# CITY OF ALBUQUERQUE

August 31, 2015

**Re: Aztec Special Education Facility  
Erosion Sediment Control Plan  
Engineer's Stamp Date 6-4-15 (H20E033)**

SILT FENCE INLET PROTECTION
NOT TO SCALE

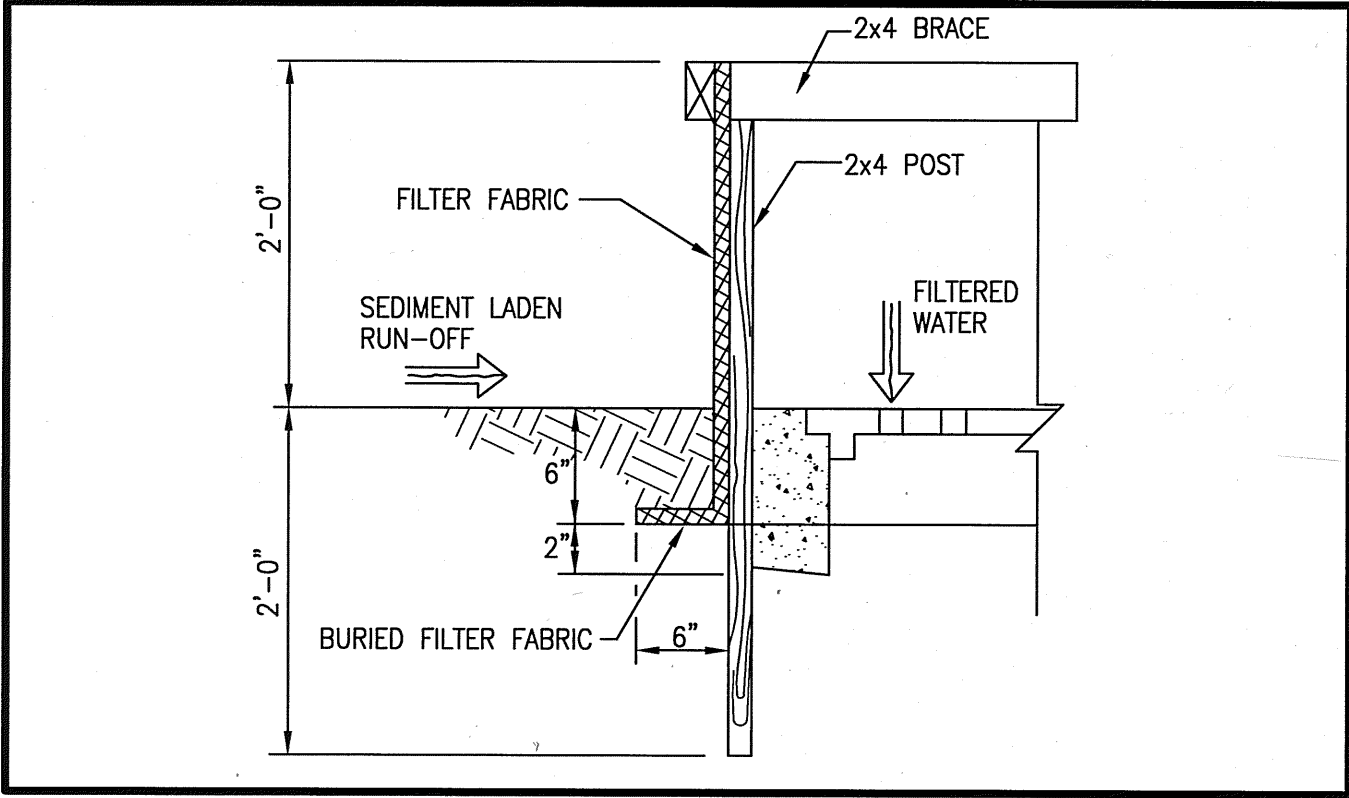
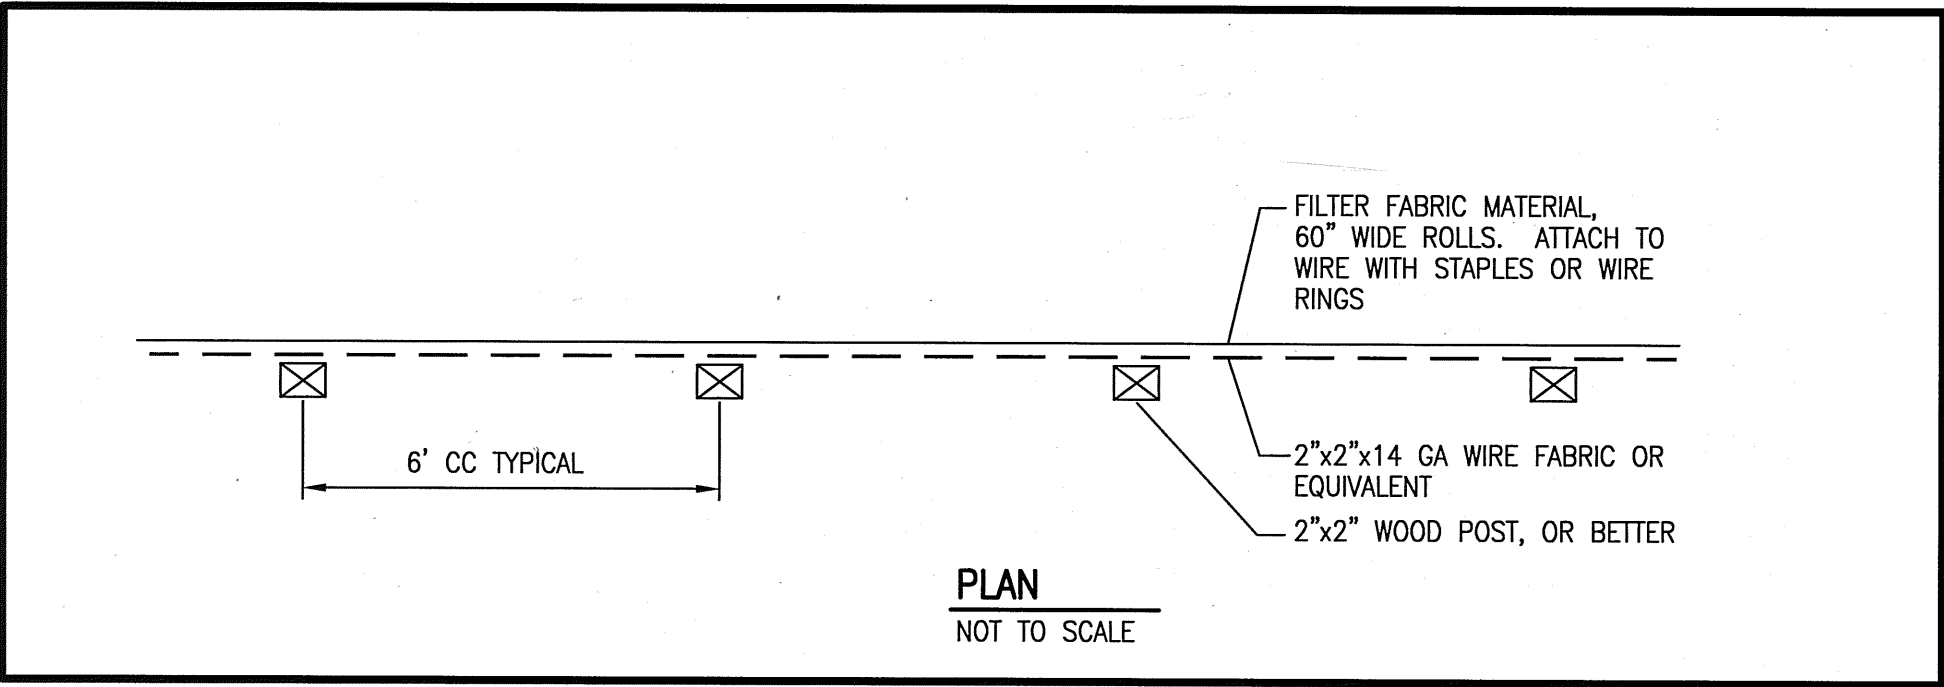
1. Consider increasing the rock size of the construction entrance to 3"-6" as they create more bounce.
2. Consider using wattles rather than silt fence for inlet protection as they are more permeable. Of course, they can be overtopped and therefore not provide as good as protection as the silt fence inlet protection shown in the detail. The design storm for BMPs is the 2 yr-24 hour storm, which in this location is about 1.3 inches.
